Recommendation Report for Planning Permission for Works or Extension to a Dwelling

REF NO: BR/323/18/HH

LOCATION: 4 Parklands Avenue
Bognor Regis
PO21 2BA

PROPOSAL: Two storey side extension and internal alterations

PROPOSED PLANS

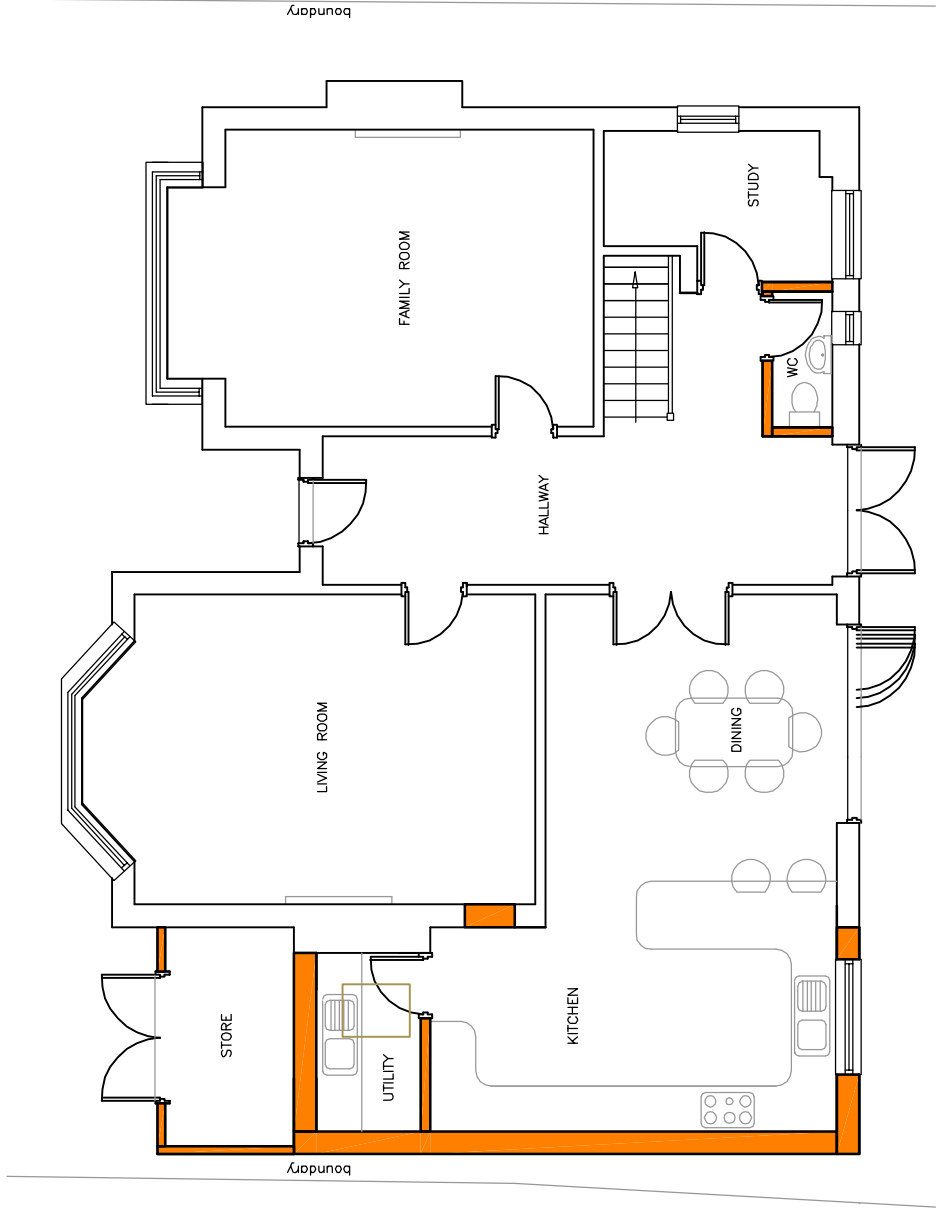
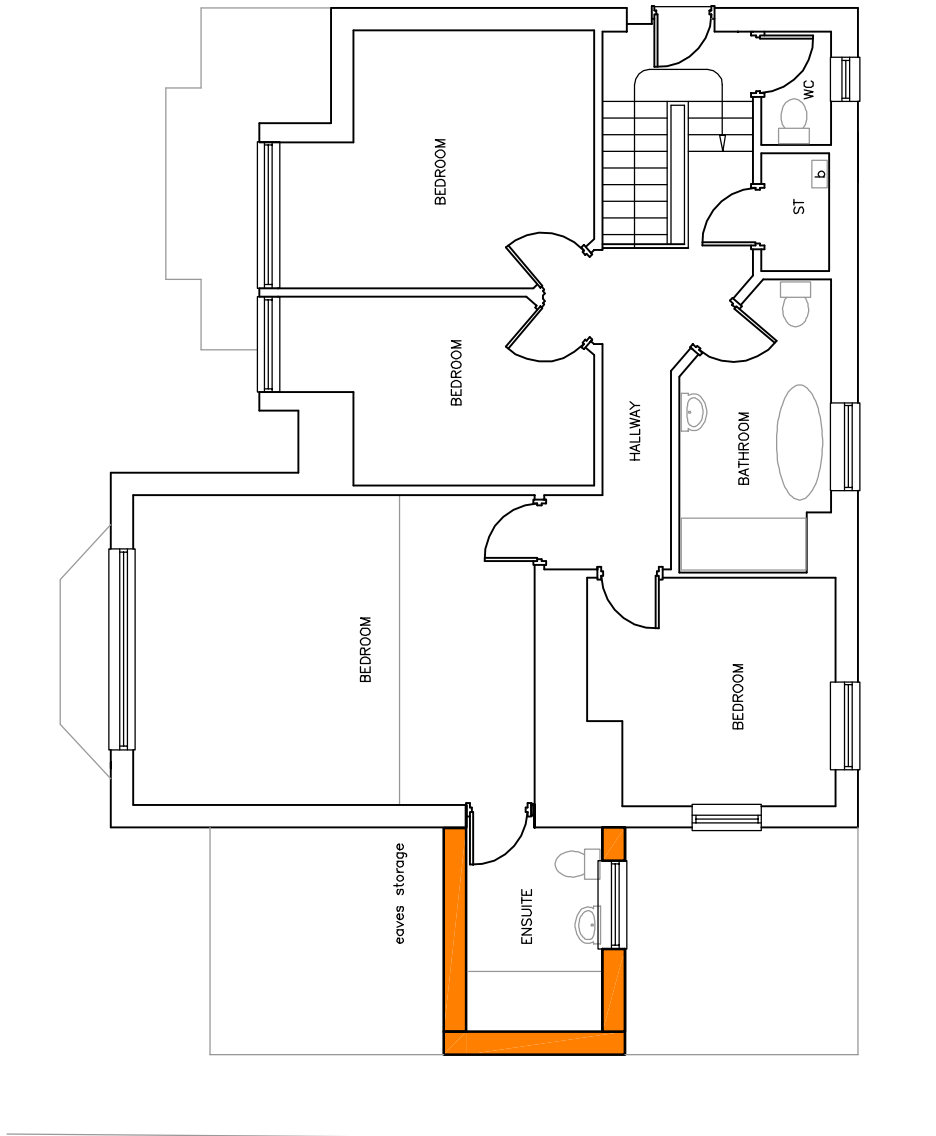
The proposed two storey development will extend from the eastern elevation at a depth of 3.1m along the full side elevation. It will have a catslide roof and therefore will have a height of 2.3m to the front elevation of the dwelling which will increase to a maximum 6.1. To the rear the height will then reduce to single storey at 3.3m.

The extension will be sited close to the boundary with only 0.3m retained to the eastern elevation. Whilst this is close to neighbouring property due to the varied height of the proposal and with it retaining its separation to the front and rear of the property it is not considered to appear adversely overbearing upon these elevations.

The proposal will install 1 additional window at first floor level and a velux to the front however this will be above finished floor level. There is 6m retained to the rear boundary and with a public footpath sited behind this the extension is not considered to provide any adverse views in addition to that which are already possible and as such does not result in any significant overlooking impacts upon neighbouring amenity to the rear or side elevation. The existing window to the side elevation will be retained.

**PROPOSED
ELEVATIONS**

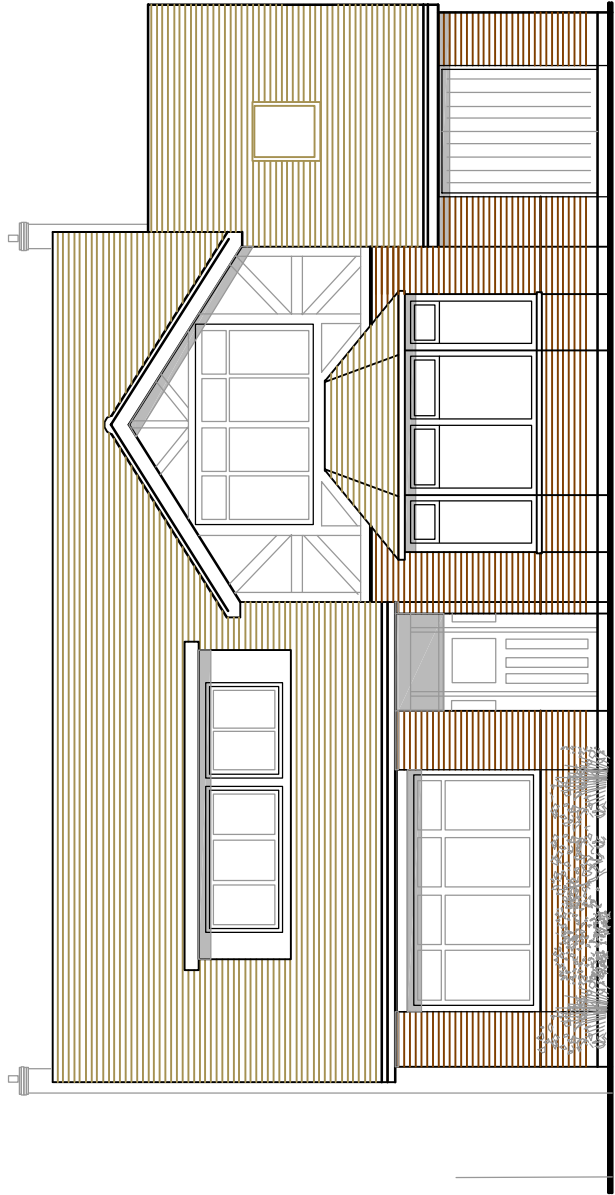
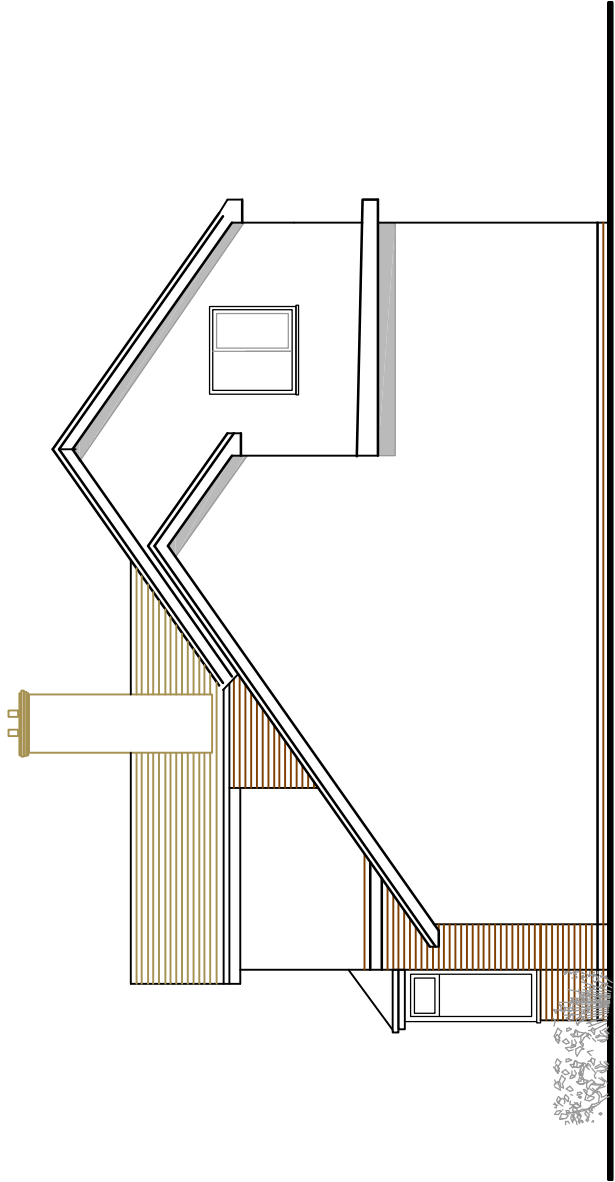
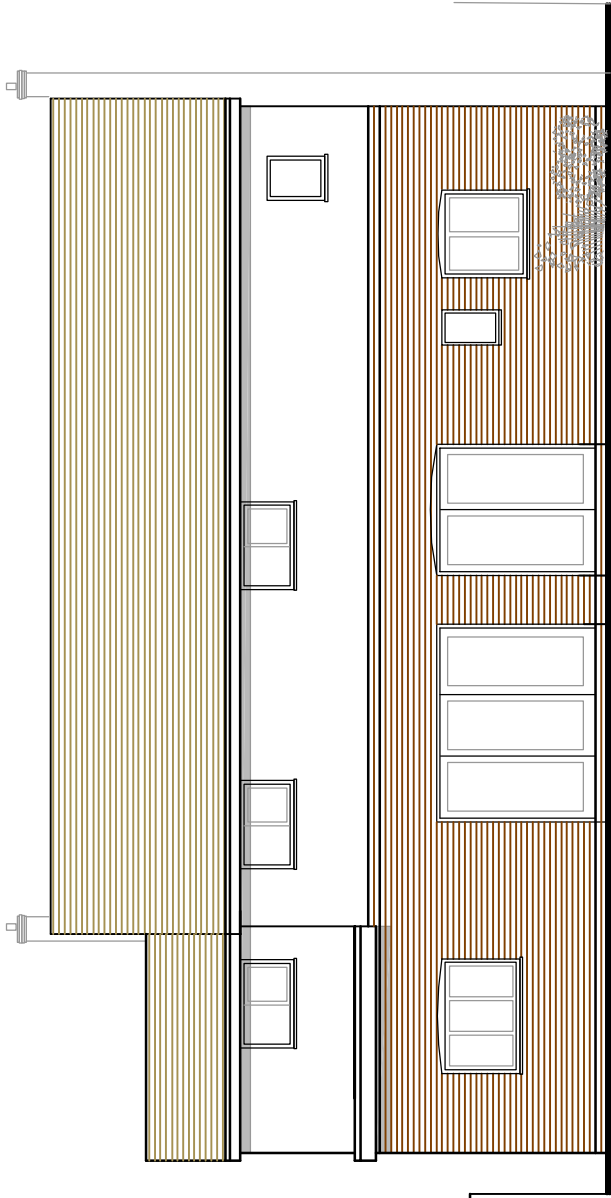
The proposed extension is situated to the side of the dwelling and as such is highly visible from the street scene. The proposed extension is positioned slightly behind the principal elevation of the dwelling as to not appear overly dominant and retains 11m to the front boundary.

The proposed extension is considered well integrated with the total height around 1.3m below that of the host dwelling. The surrounding properties are of a mixed style and design and therefore the addition is not considered to result in the property appearing out of character with the area. The proposed extension is not considered to result in any adverse impacts upon the spatial pattern or character of the area and accord with DDM1 and DDM4 of the Arun Local Plan.

The neighbouring property to the east has 2 windows to its side elevation, 1 to the ground floor and 1 to the first floor. The proposed extension is therefore considered to give rise to some overshadowing however this is not considered significant due to the windows being secondary in nature and with the design of the roof and it reducing to single storey height at the rear.
